**CROSSROADS NORTH PRELIMINARY PLAN**  
**LETTER OF INTENT**

Colorado Springs Equities, LLC ("The Applicant") requests approval of the Crossroads North Preliminary Plan that includes 11 commercial lots, six (6) tracts for stormwater detention/water quality, public rights-of-way, transportation improvements including private roads, pedestrian facilities, utility infrastructure, landscape buffers, and a preliminary landscape plan.

SHEET 3. SPECIFIC NOTES

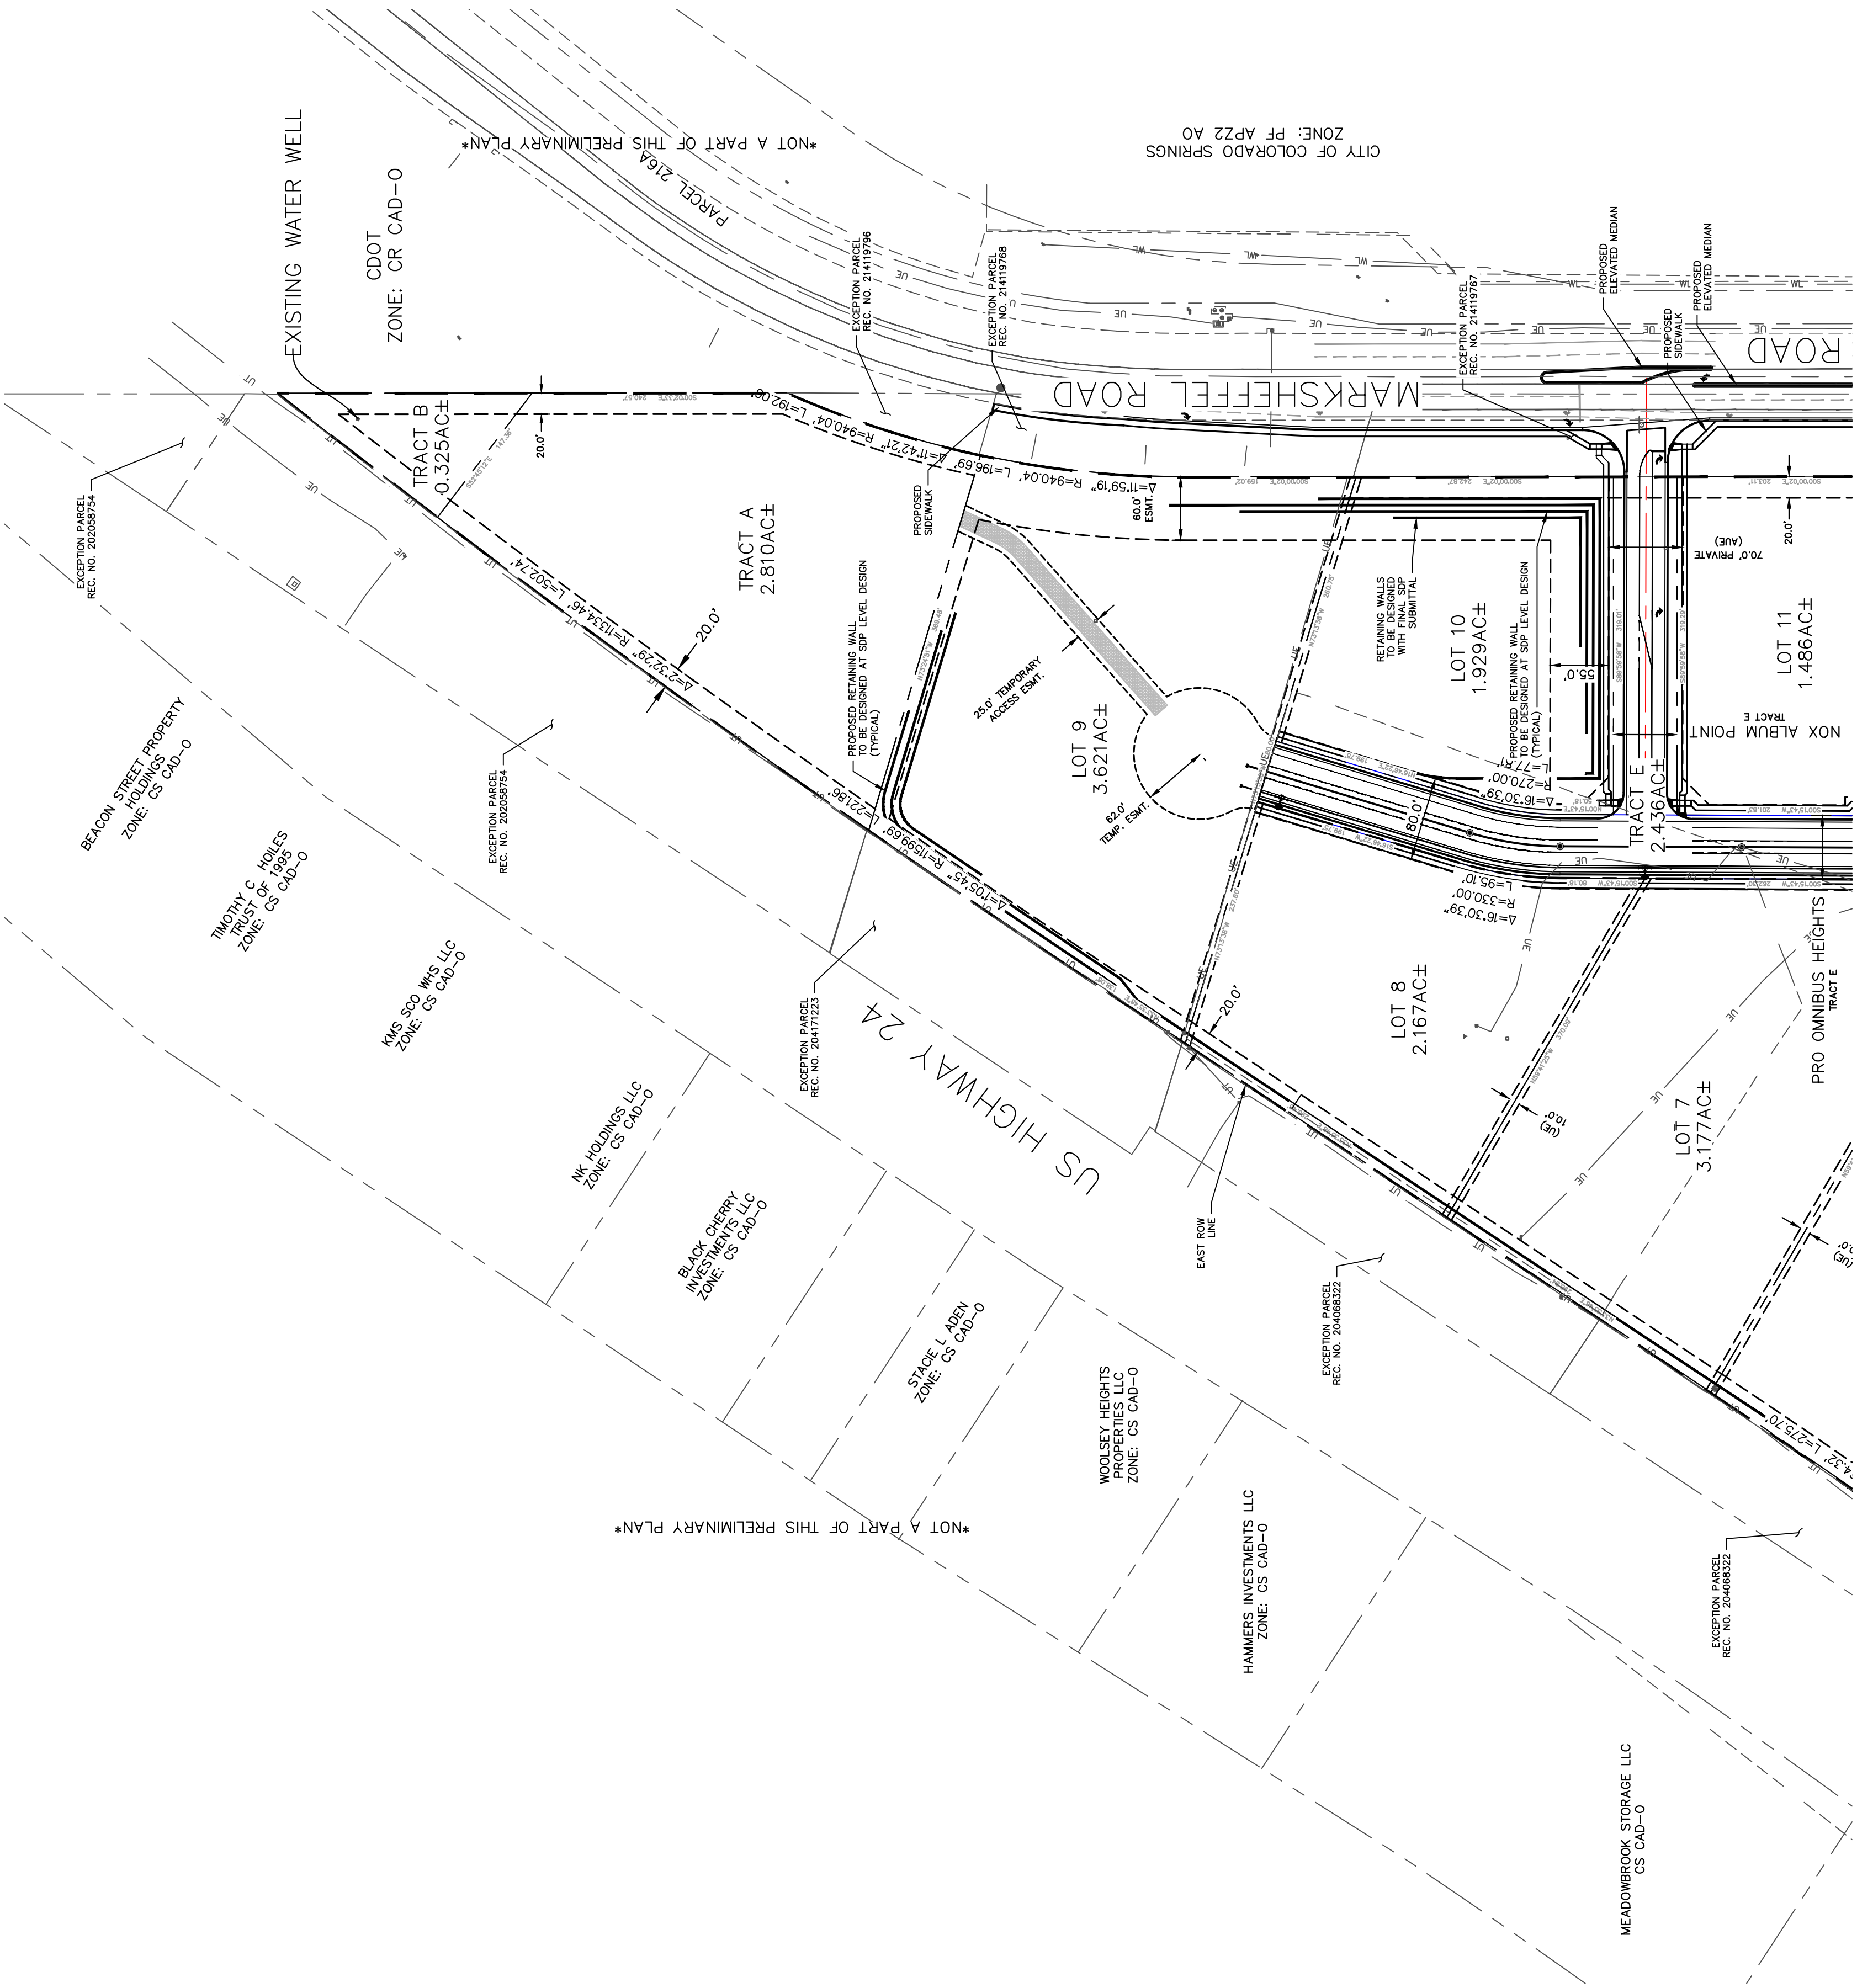
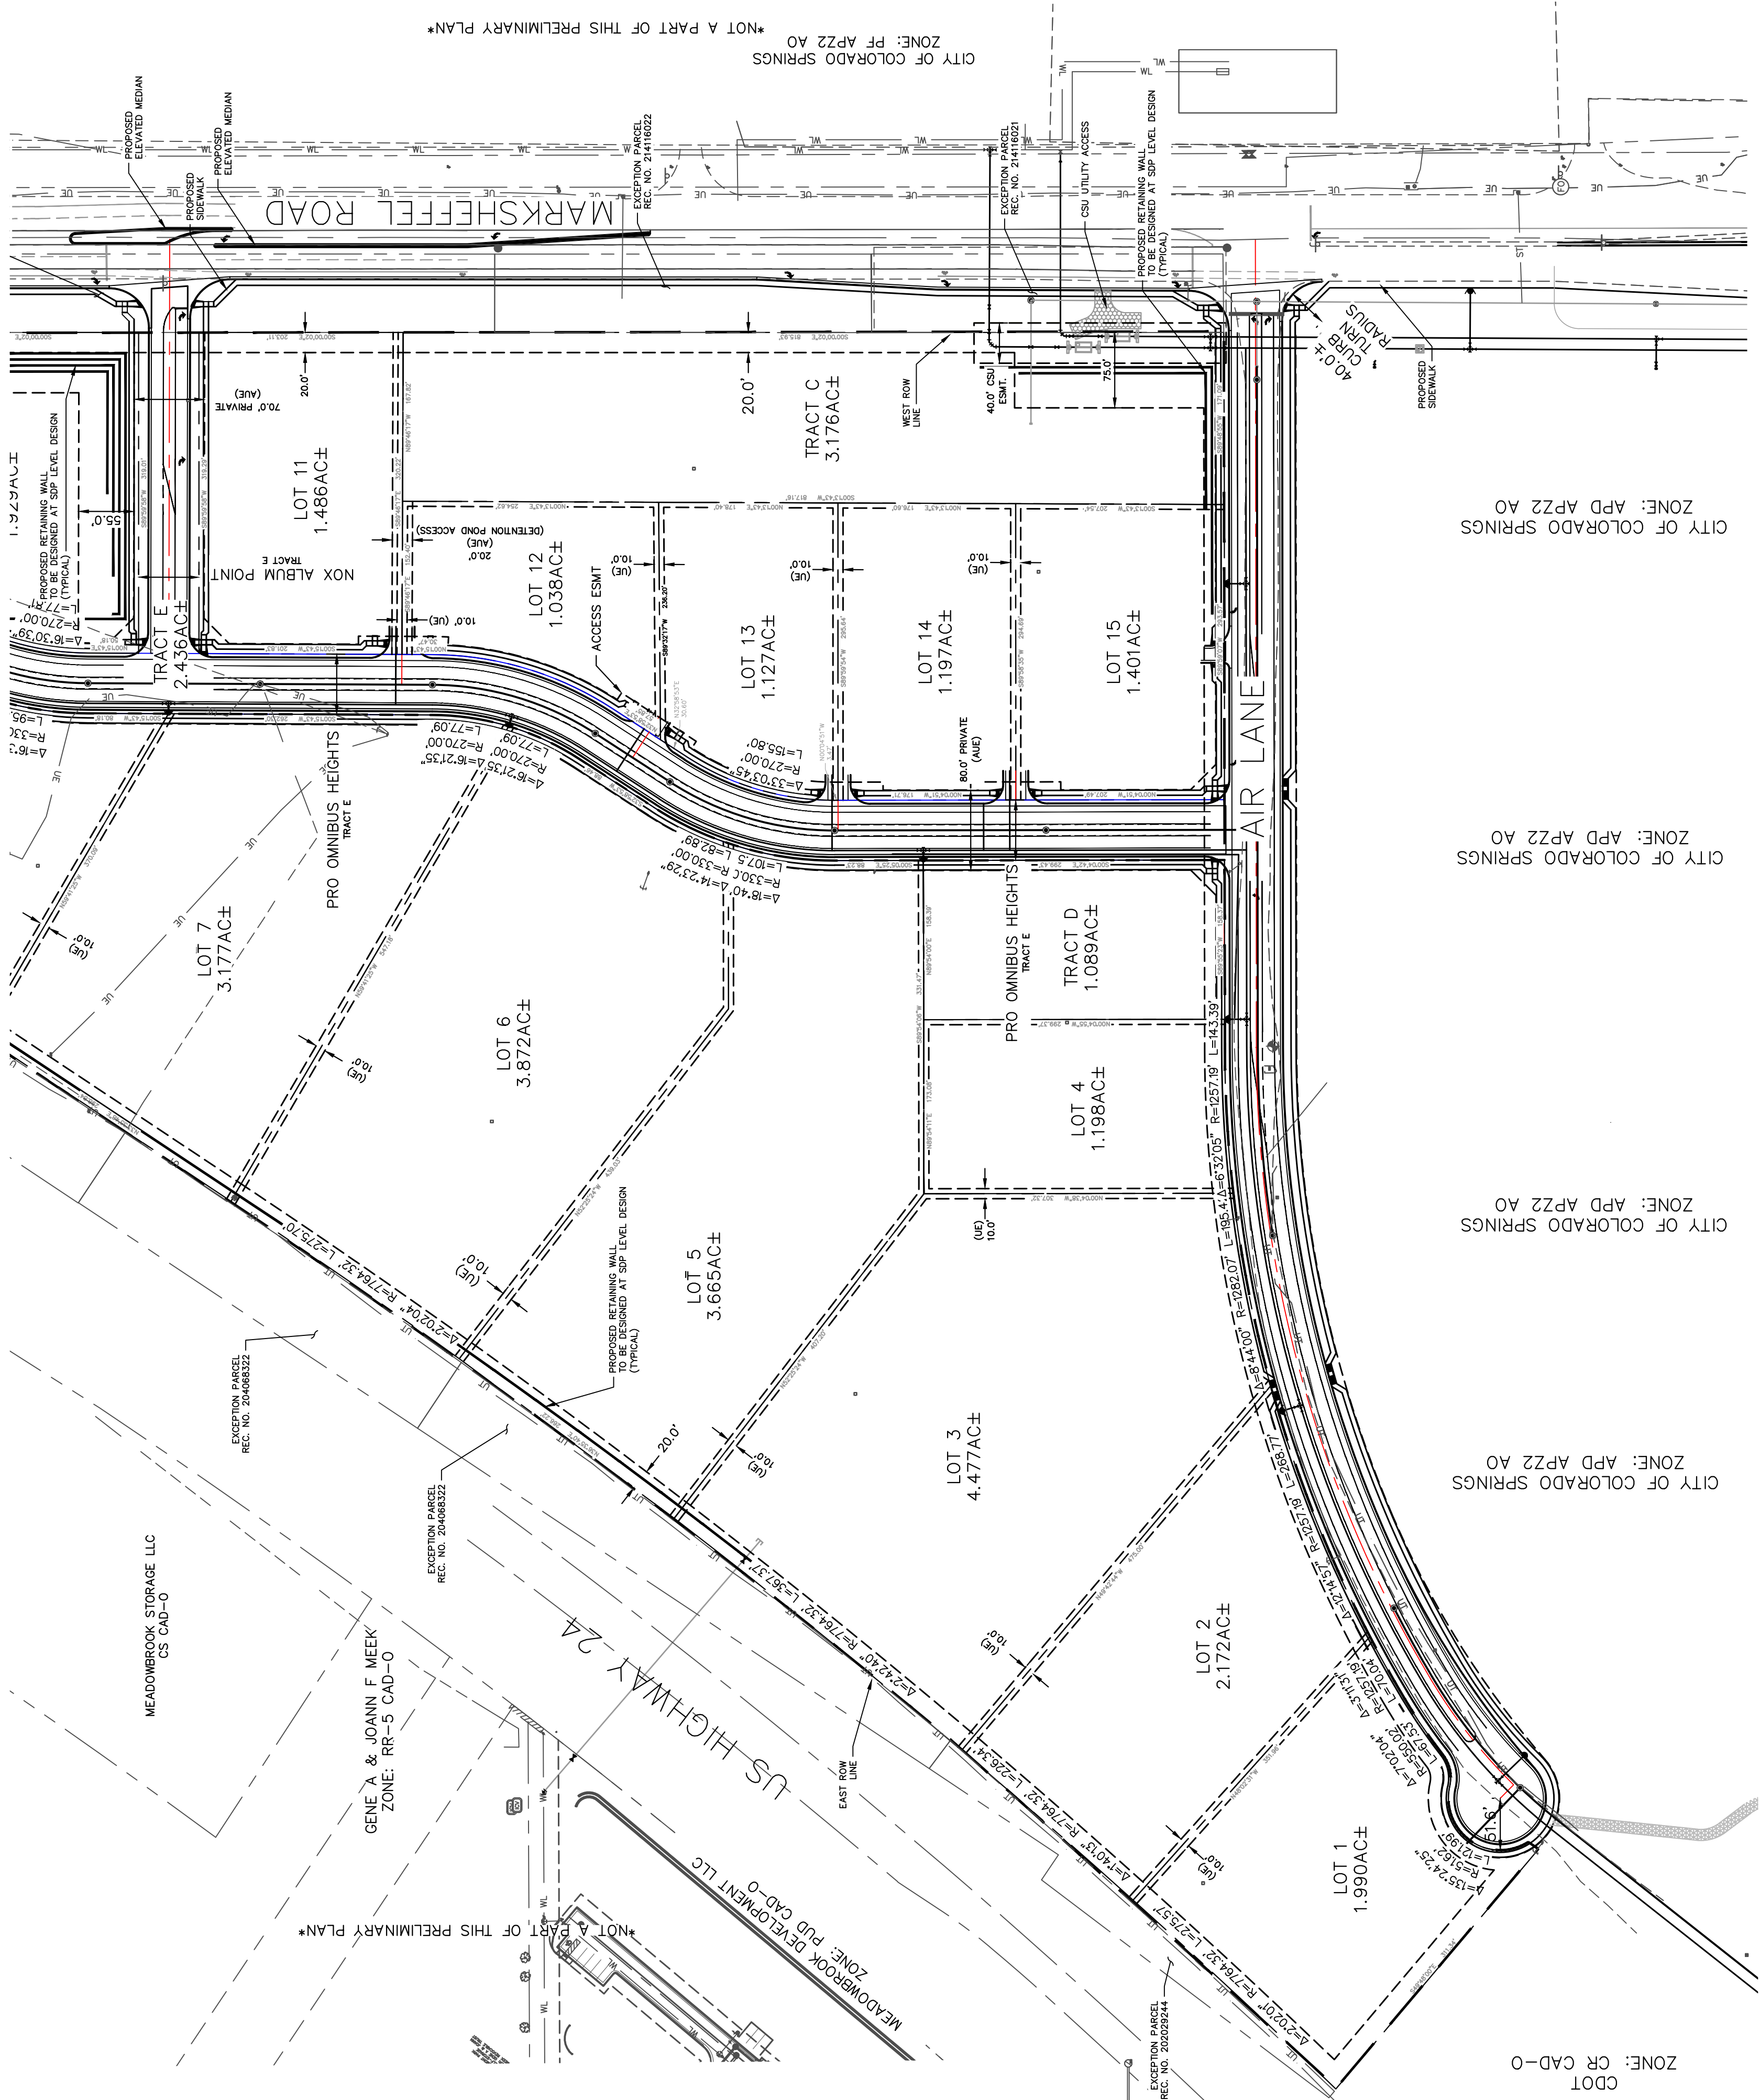
are you sure not private roads- where is a public road tract on plan?

please specifically show trails/sidewalks in tracts that are specifically for pedestrian facilities- i don't think thats the case for all tracts? Are here sidewalks adjacent to private road tract or within them? carry this over to plan.

please tell what the true use and ownership is for each tract, do not combine uses..see comments on planset.
